Re: Objection to MP08_0244 MOD 1 Modification Request for Mixed Used Development at 23-37 Lindfield Avenue and 11 Havilah Lane, Lindfield

As a resident of Lindfield, I/we wish to lodge an objection against the proposed Modification of the subject development based on the following grounds:

Drawing Title
BASEMENT 3 PLAN

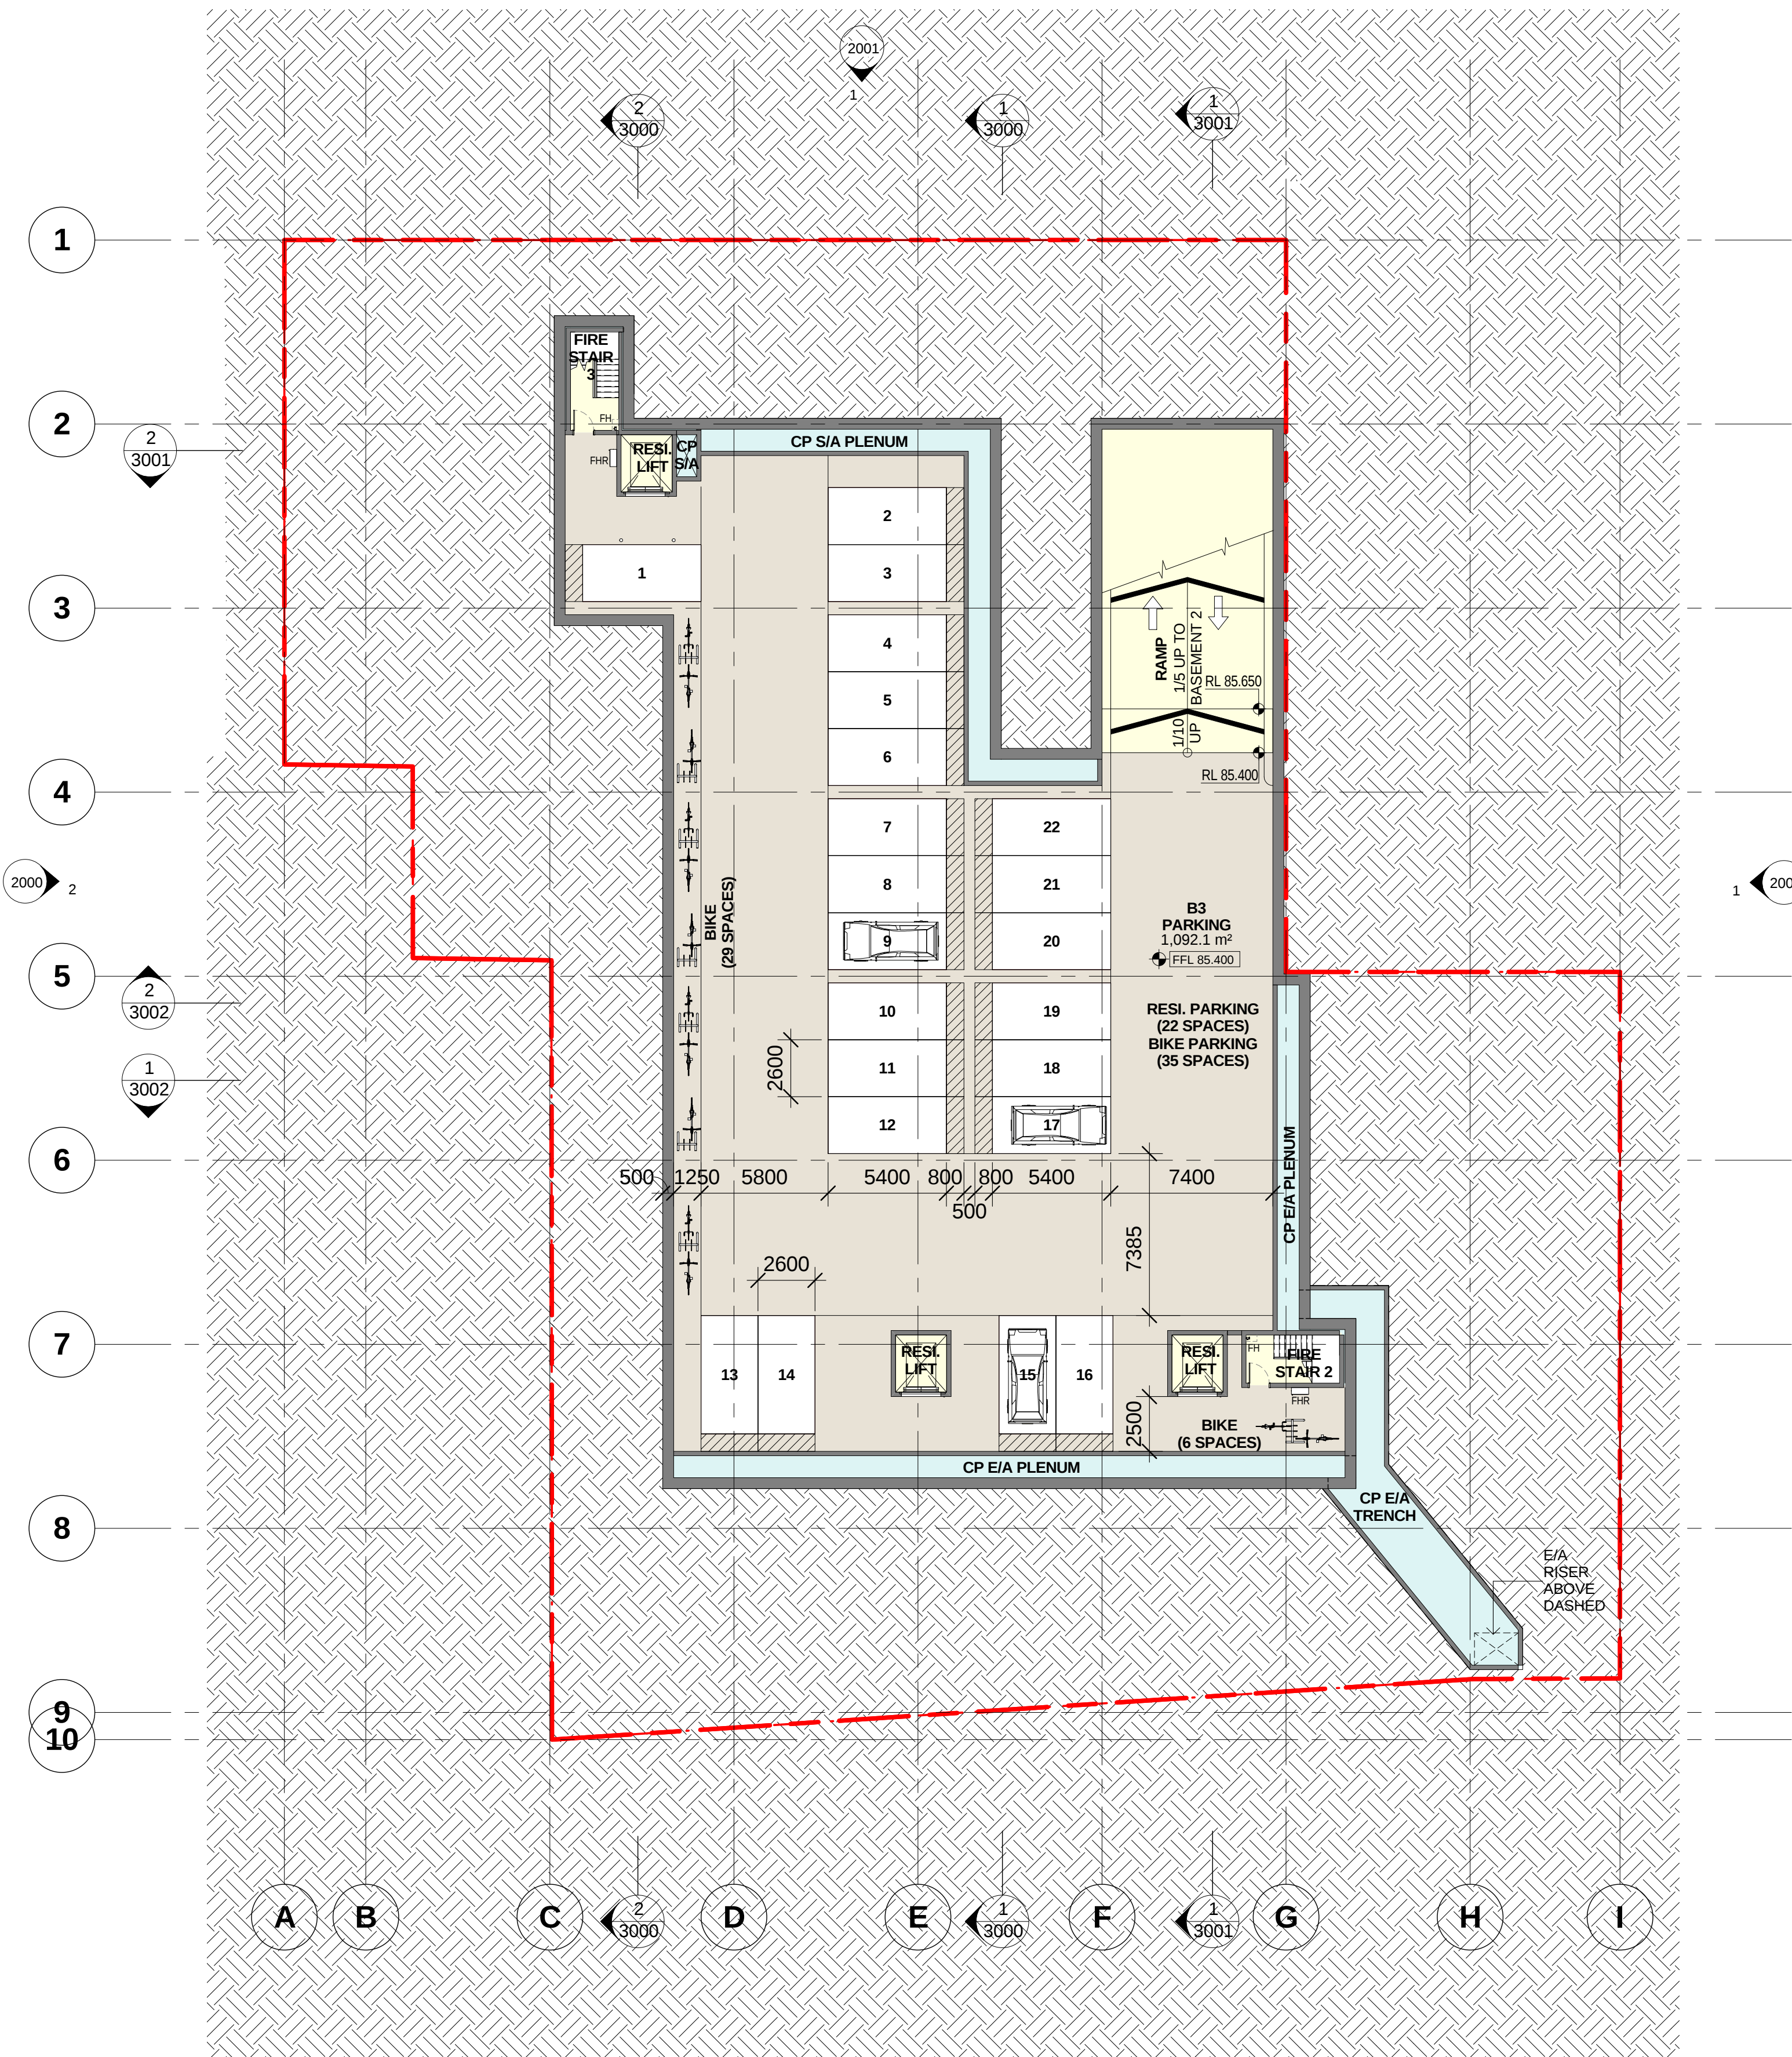
- ✓ Car spaces were identified as inadequate for the retail component and this has not been addressed relative to the remaining retail space proposed. The 25 car spaces counted as part of council's car park are also now highly uncertain due to the proposed rezoning and potential redevelopment.

1 KOCHIA LA ELEVATION
SCALE 1 : 250

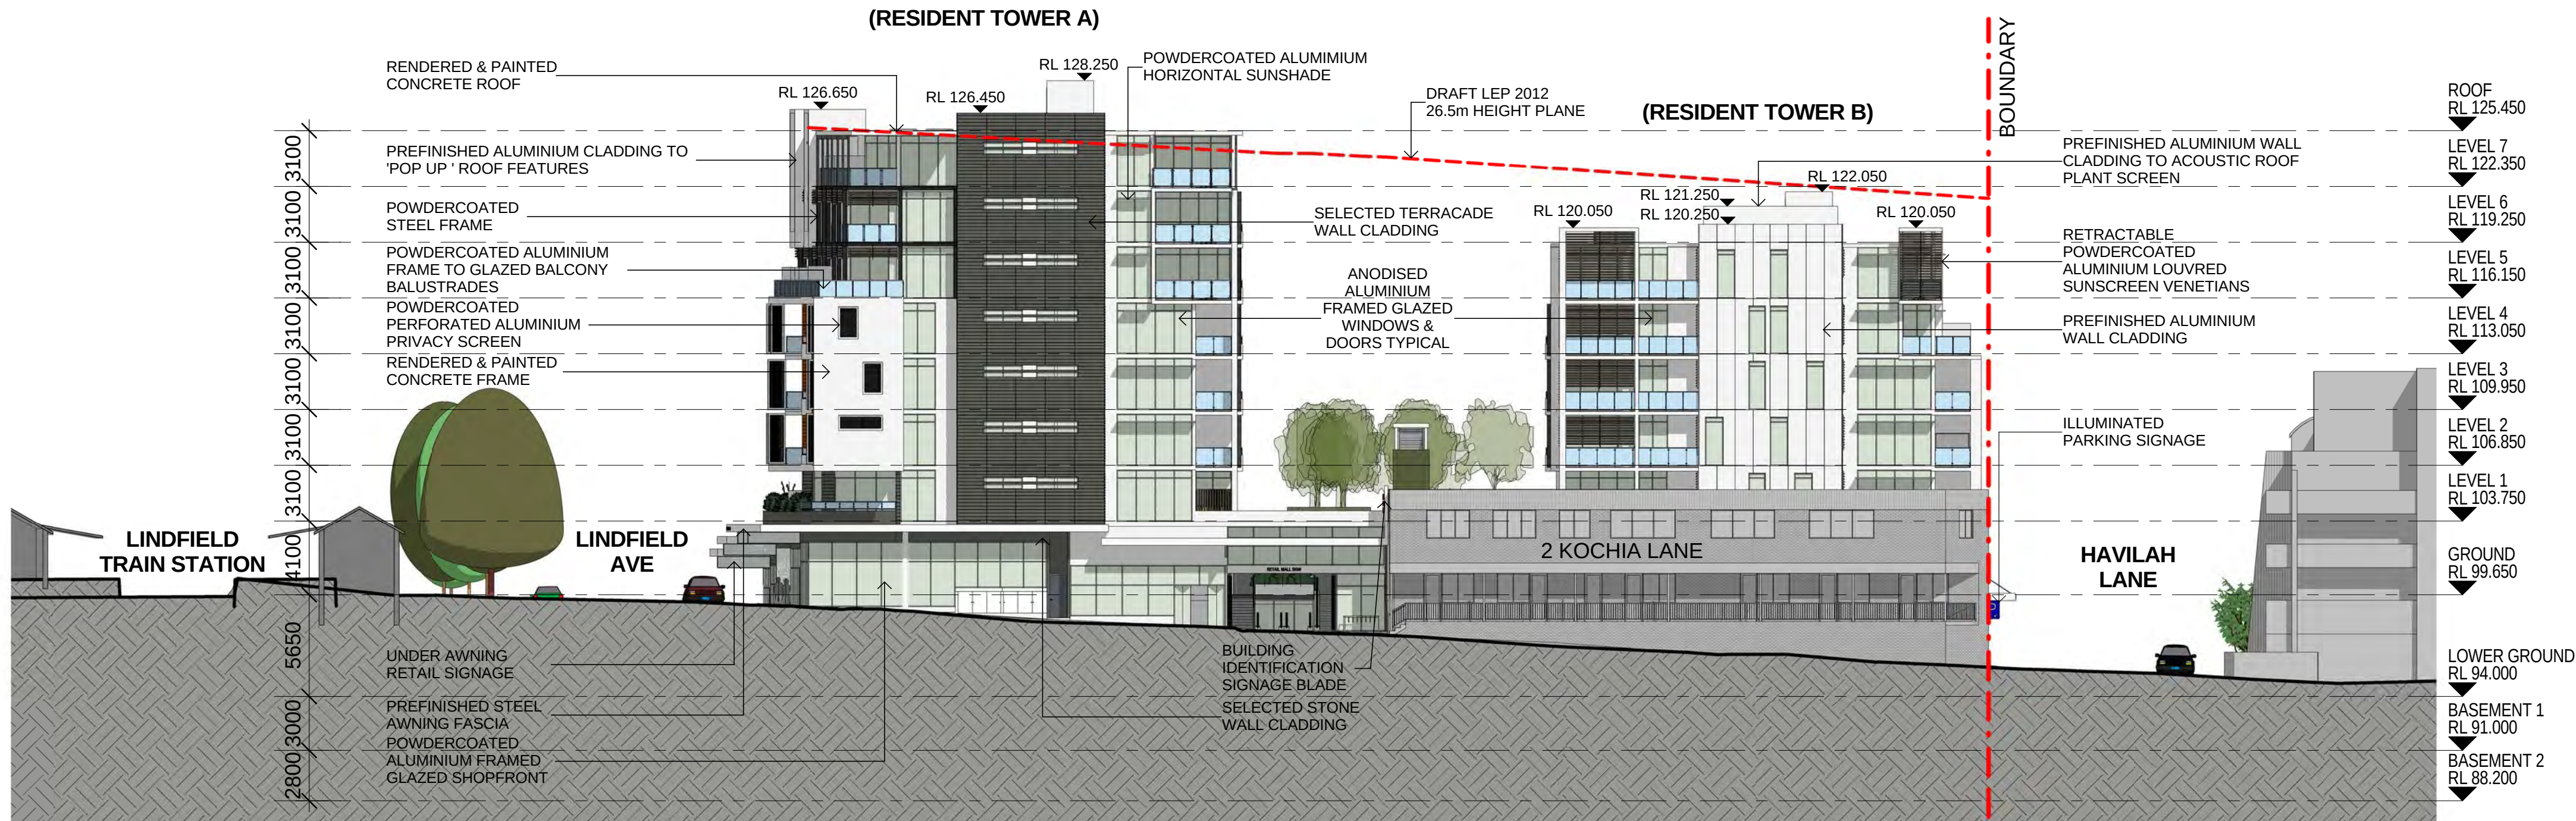
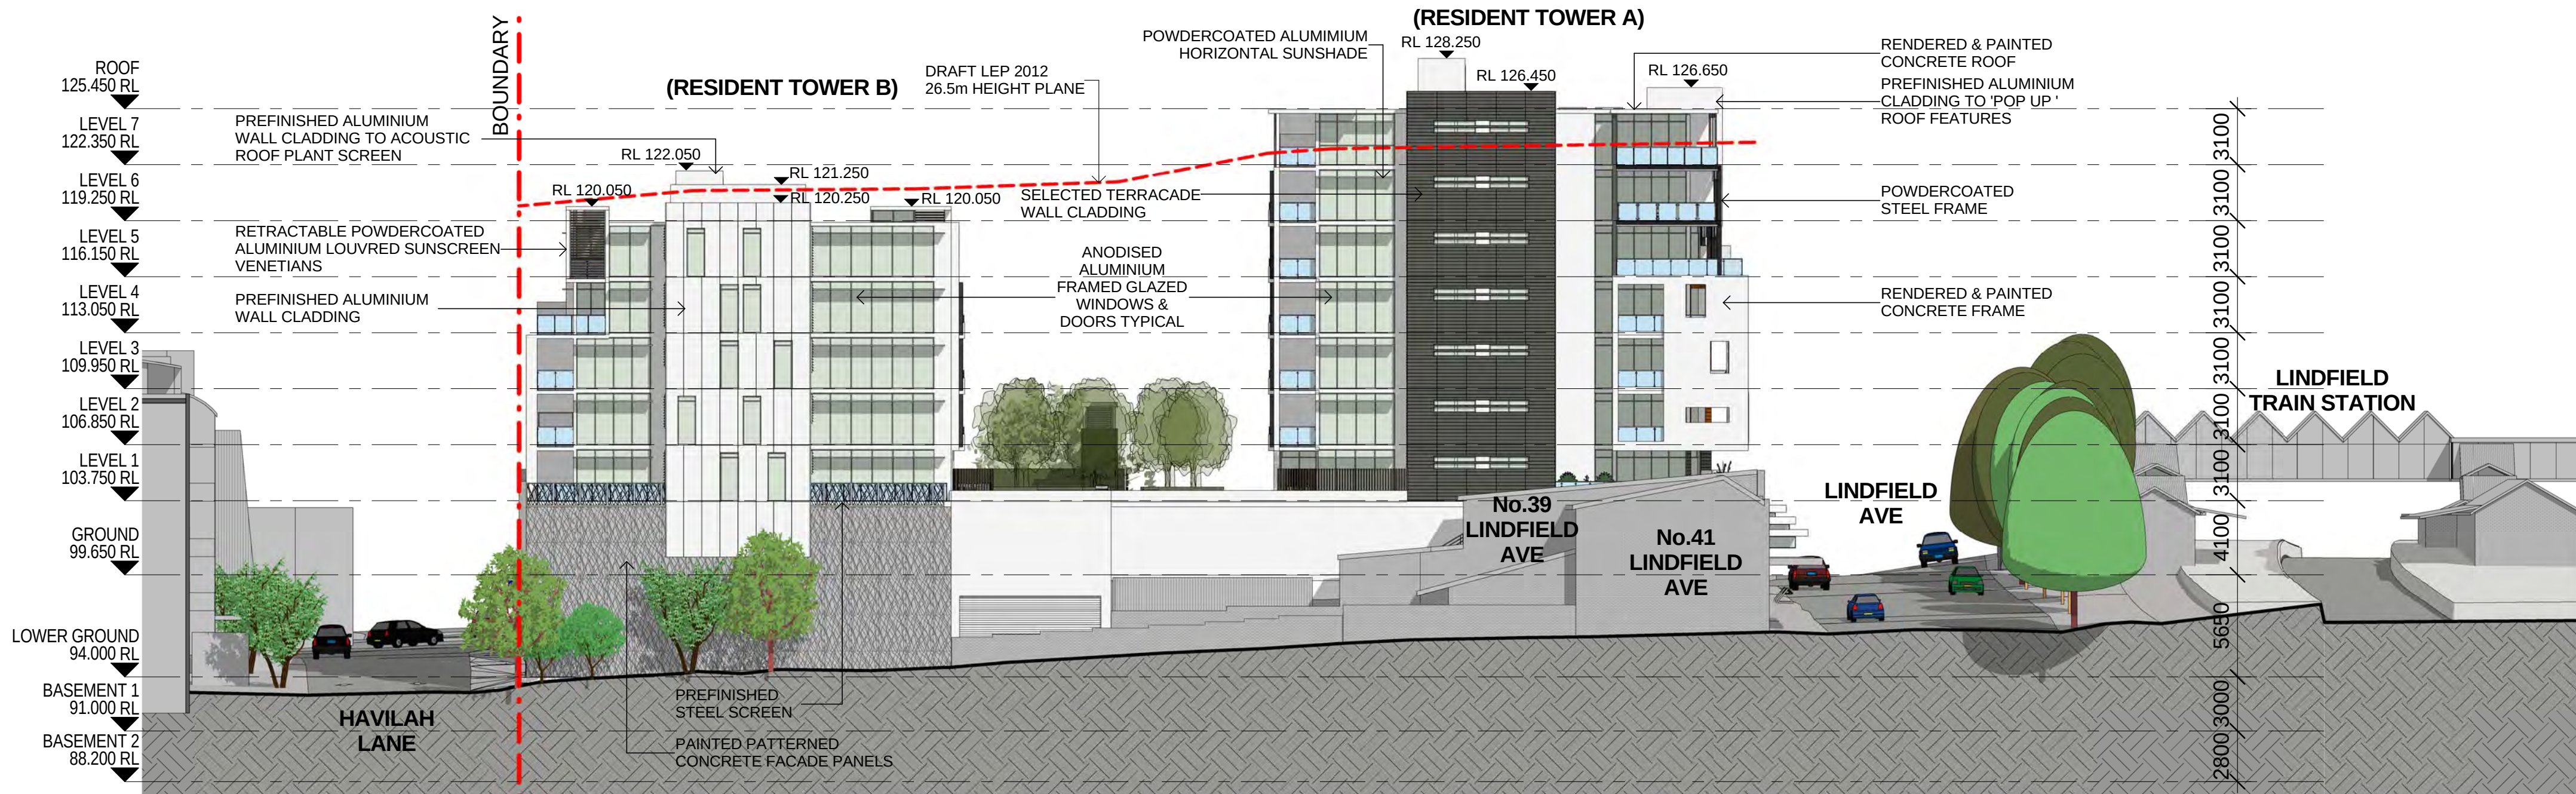
- ✓ The additional storey (combined with less set back than the approved design) on Havilah Lane now creates privacy concerns for over 40 apartments in the adjacent 8 Havilah Lane, 8 Kochia Lane and 2-8 Milray Street residences
